From: Contact Centre (CRM) <contact@ribblevalley.gov.uk>
Sent: 10 April 2024 14:25
To: Planning
Subject: Planning Application Comments - 3/2024/0126 FS-Case-604556763

Planning Application Reference No.: 3/2024/0126

Address of Development: 9 Berkshire Close
Wilpshire
Blackburn
BB1 9NG

GROUND FLOOR PLAN

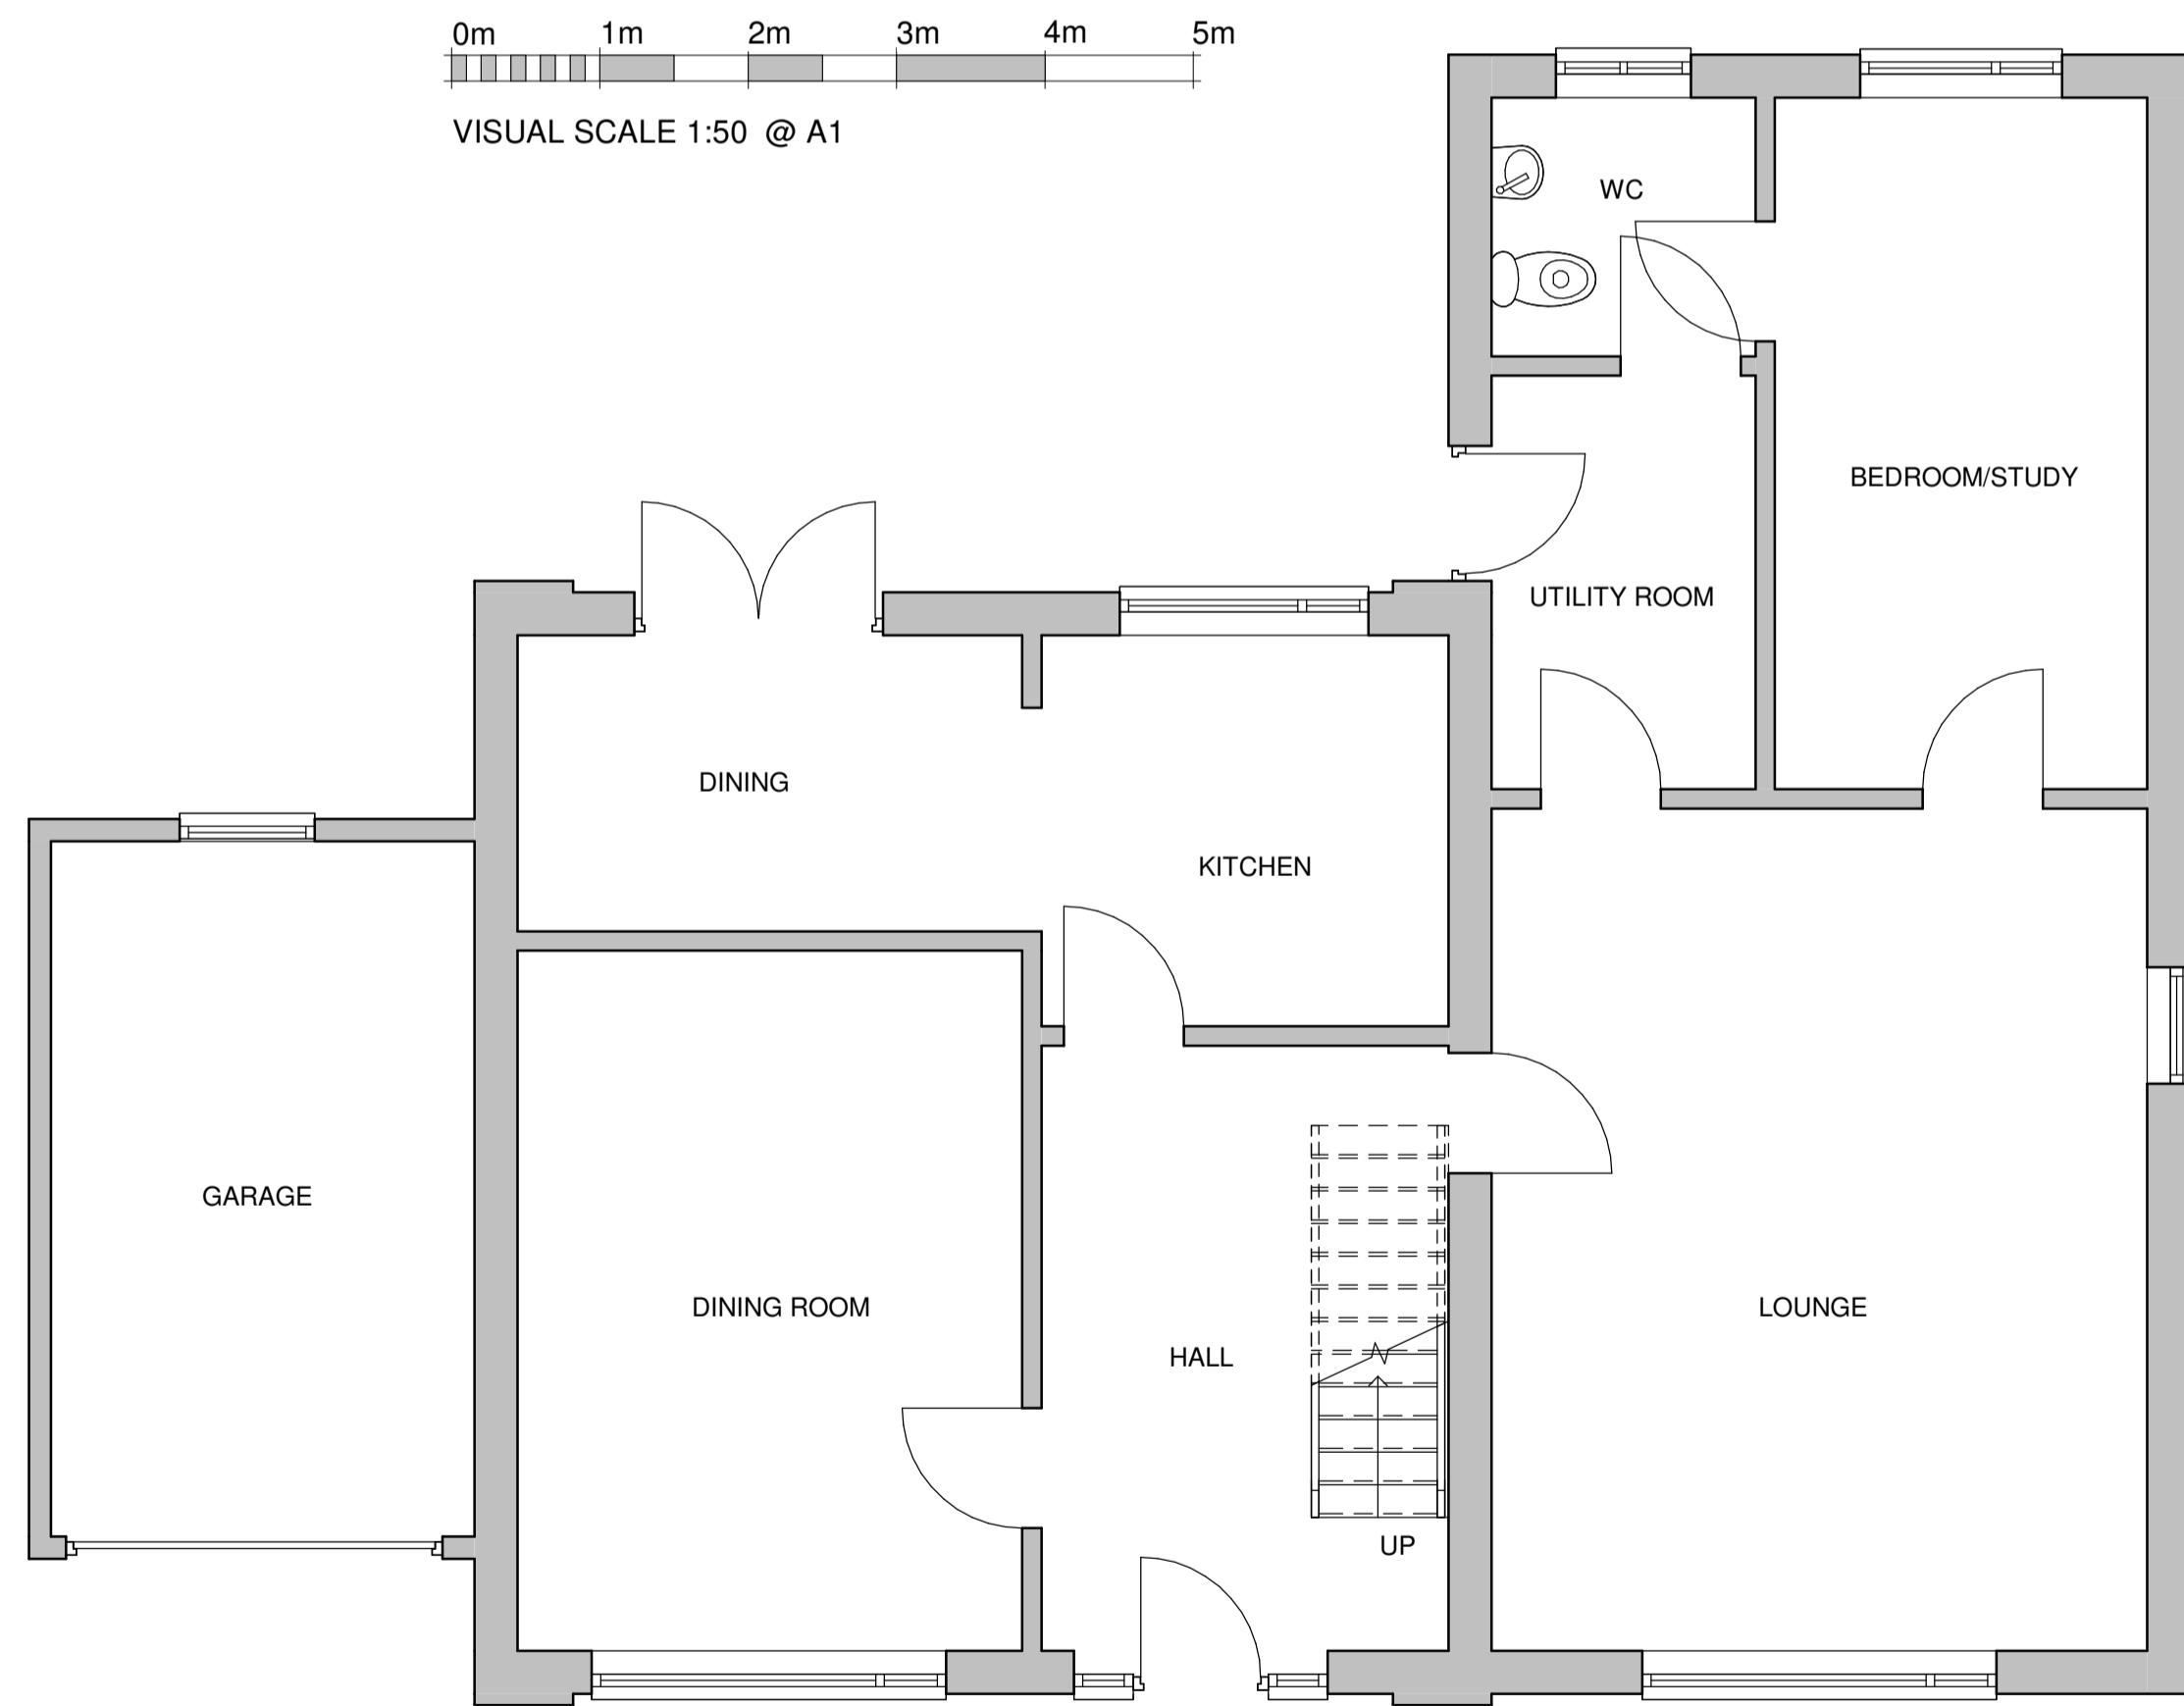
Comments: We have noticed that on the existing plan view of the house, the window pictured on the north side is incorrectly positioned closer to the front rather than the back of the house. This concerns us as to the accuracy of other aspects of the current and proposed plans.

GROUND FLOOR PLAN

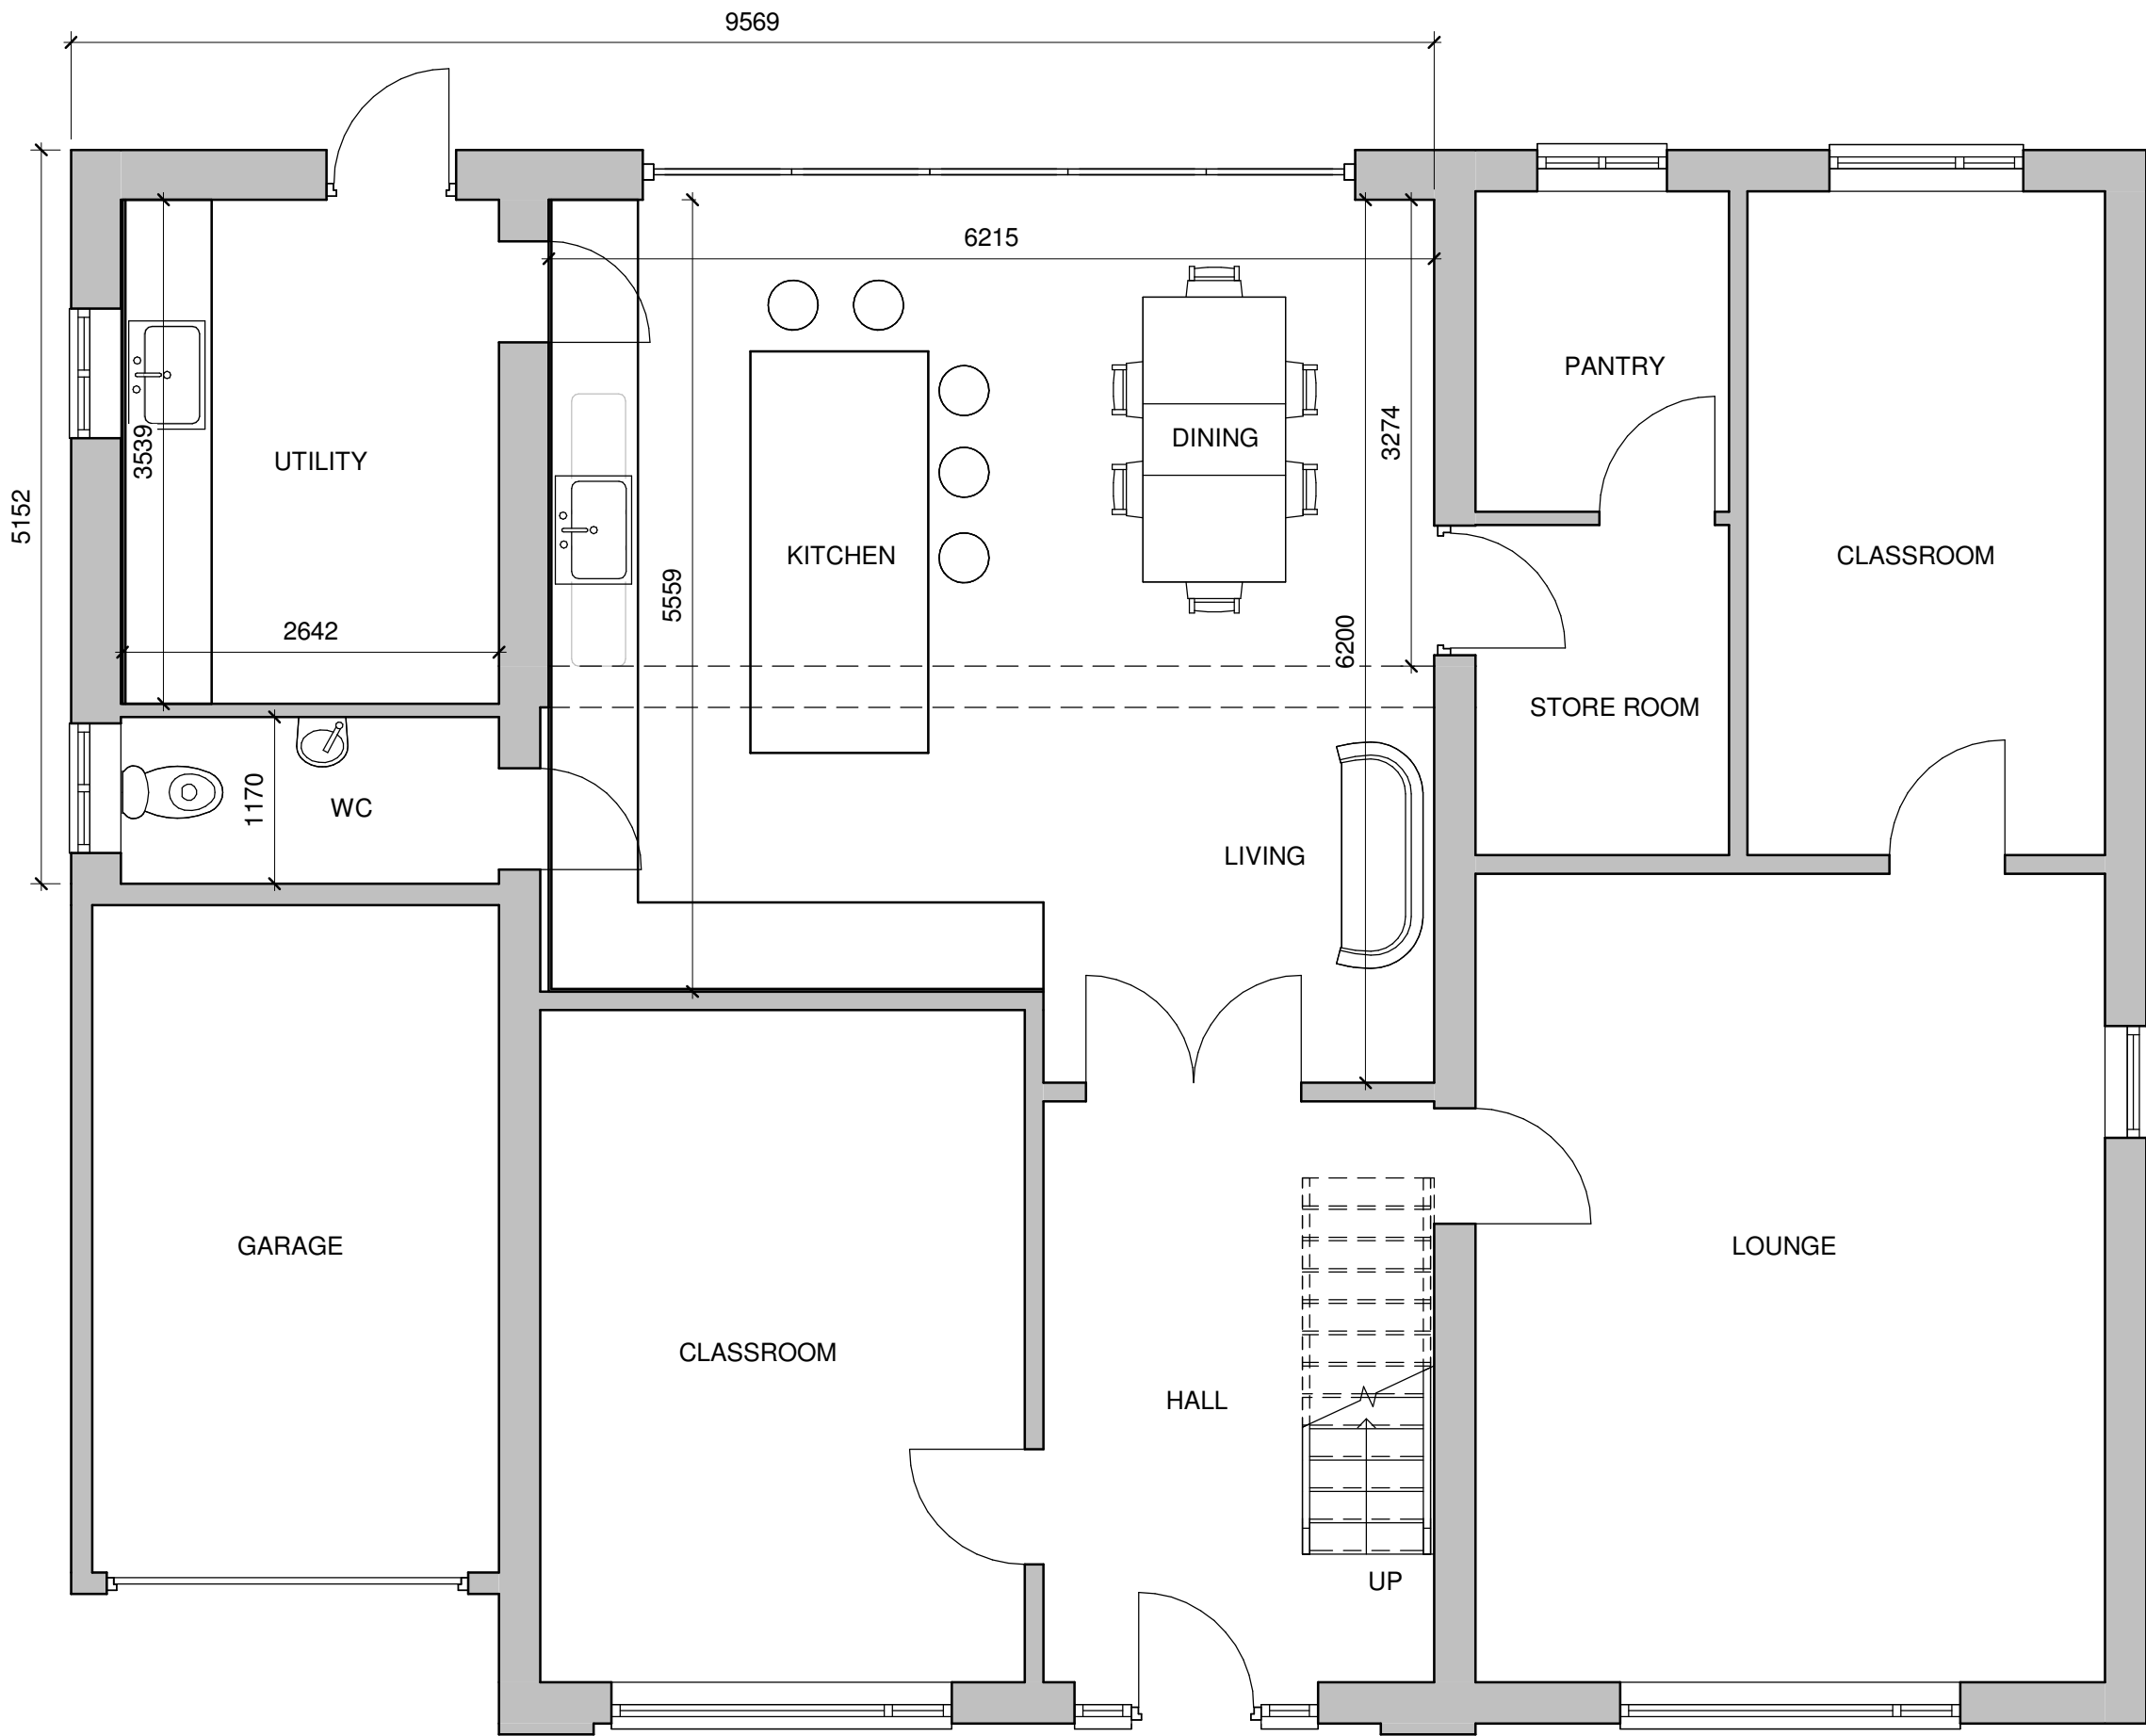
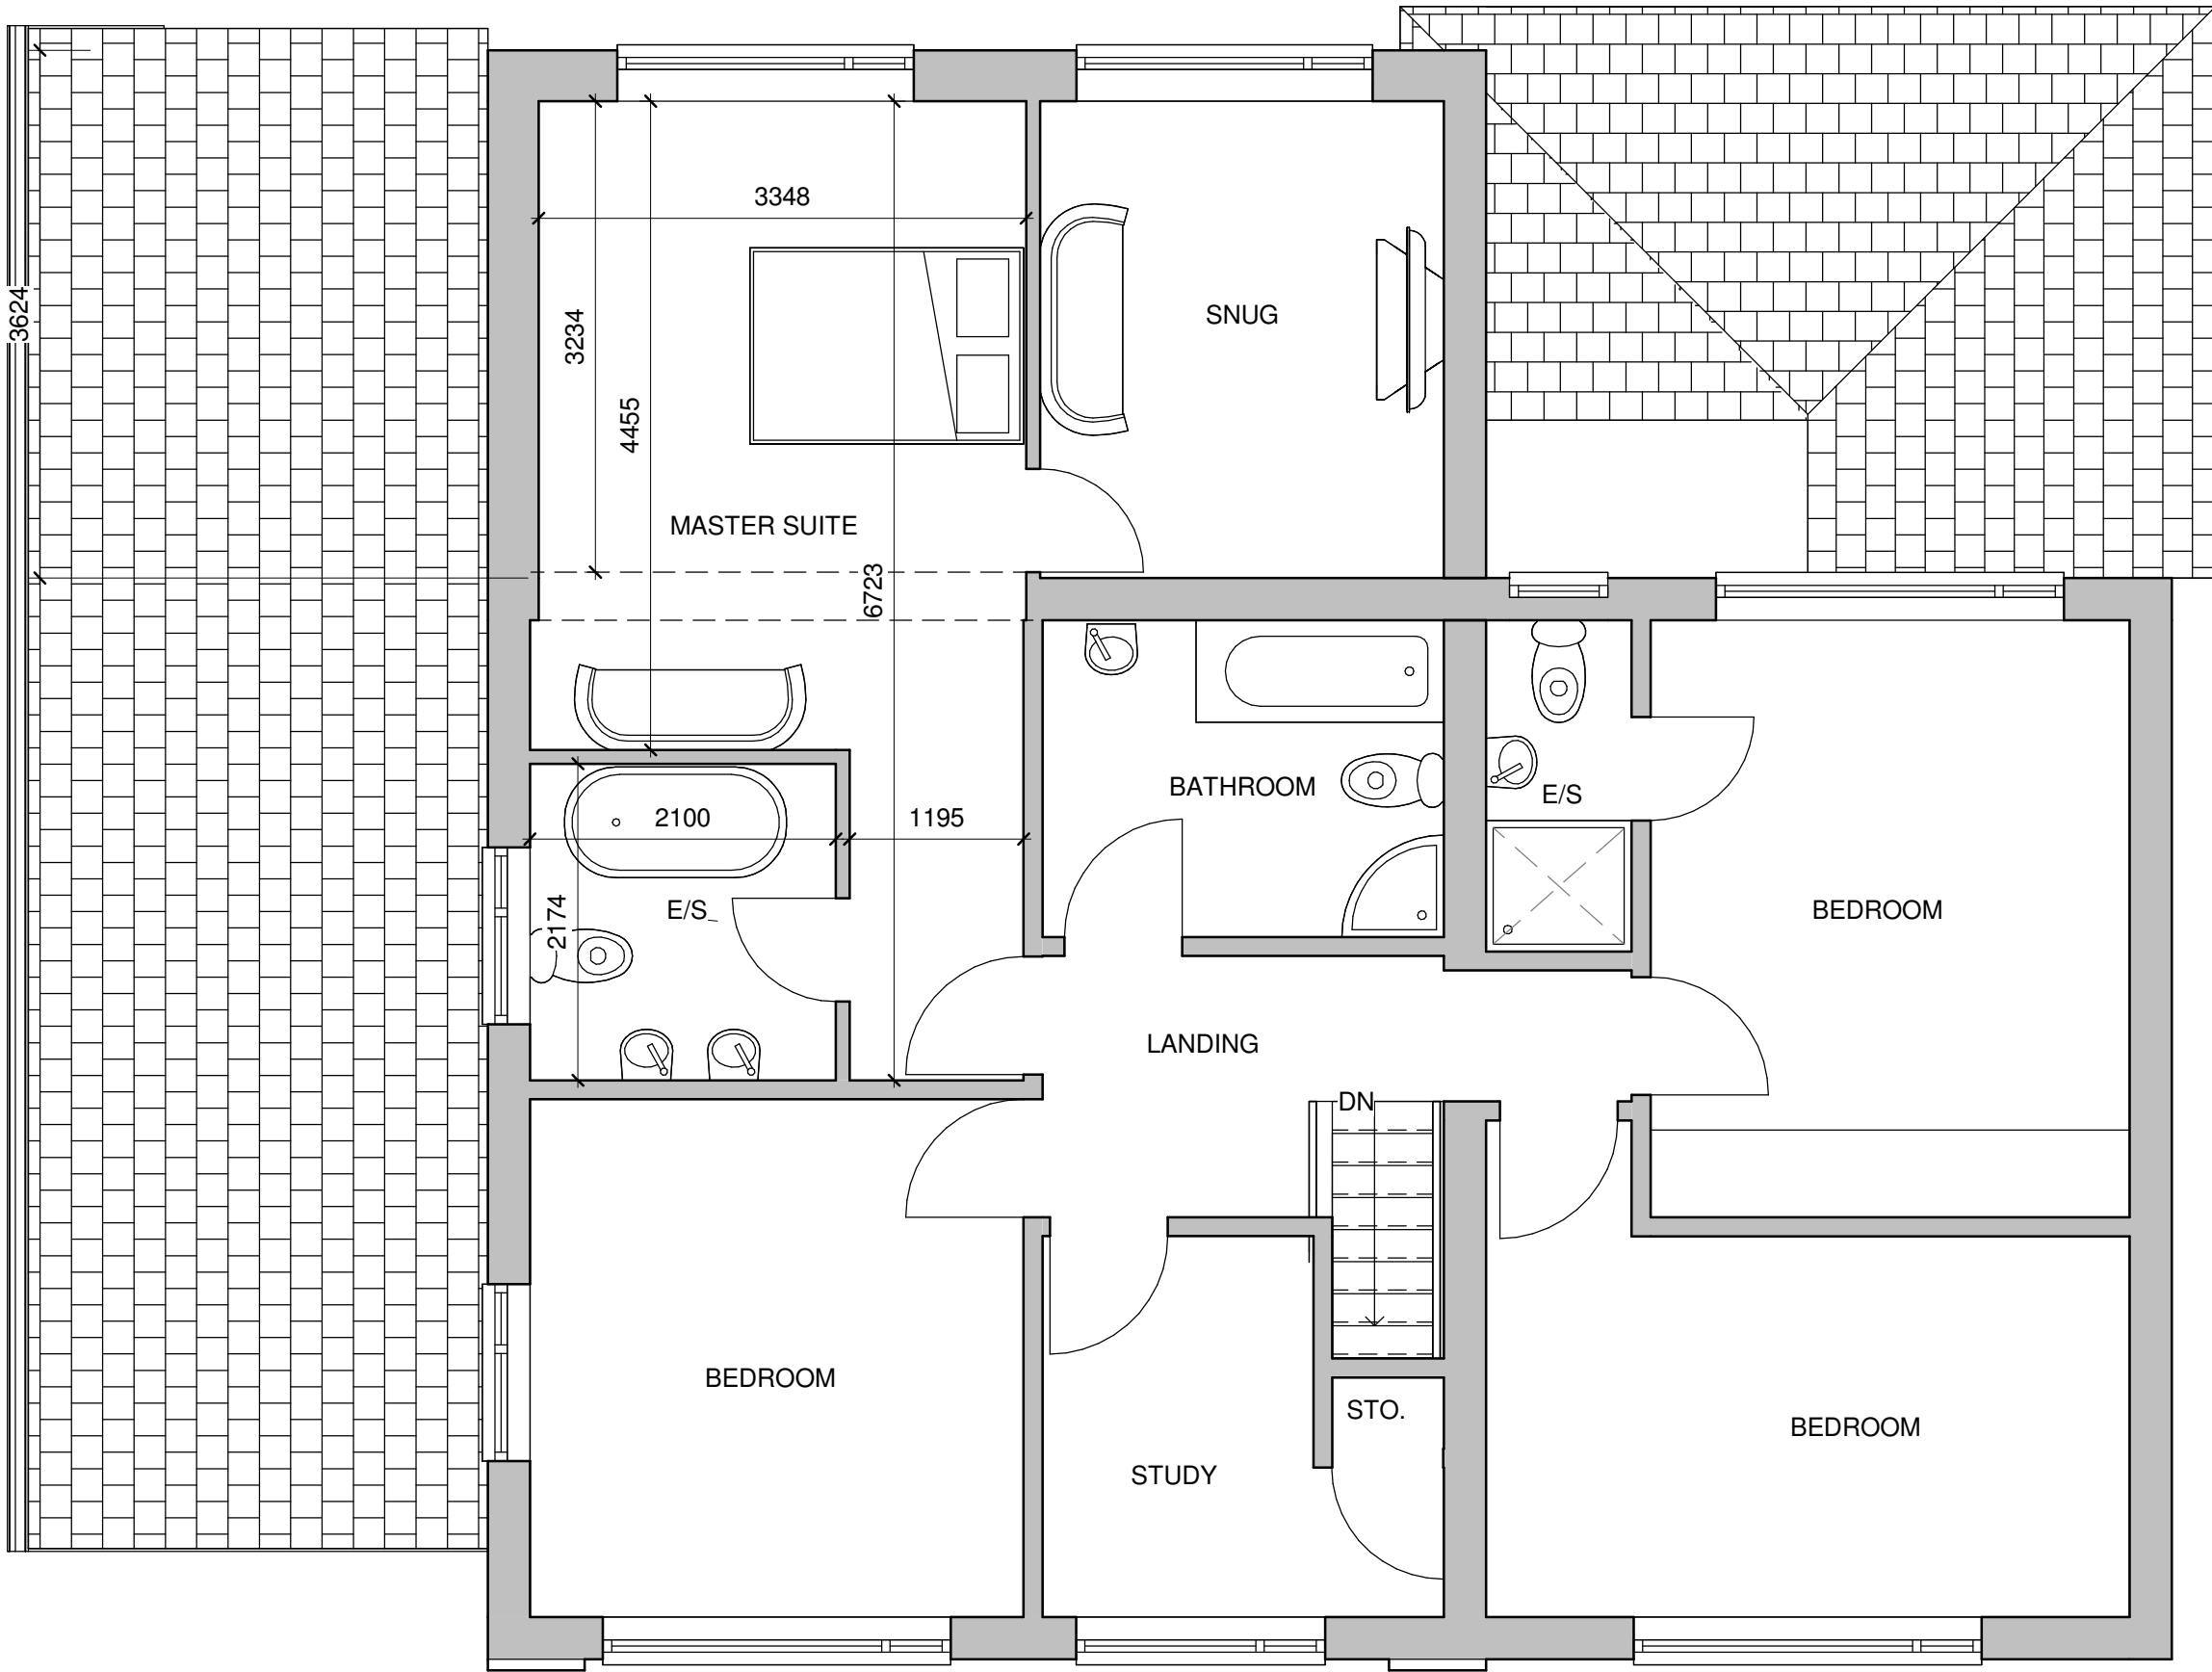
We are concerned about the impact of loss of light [REDACTED] due to the [REDACTED] of the 2 storey and 1 storey extensions, especially as the 1 storey extension is planned to go much further back, and consequently closer, than we thought.

We would request that the window on the proposed utility room is not transparent as we would feel [REDACTED]
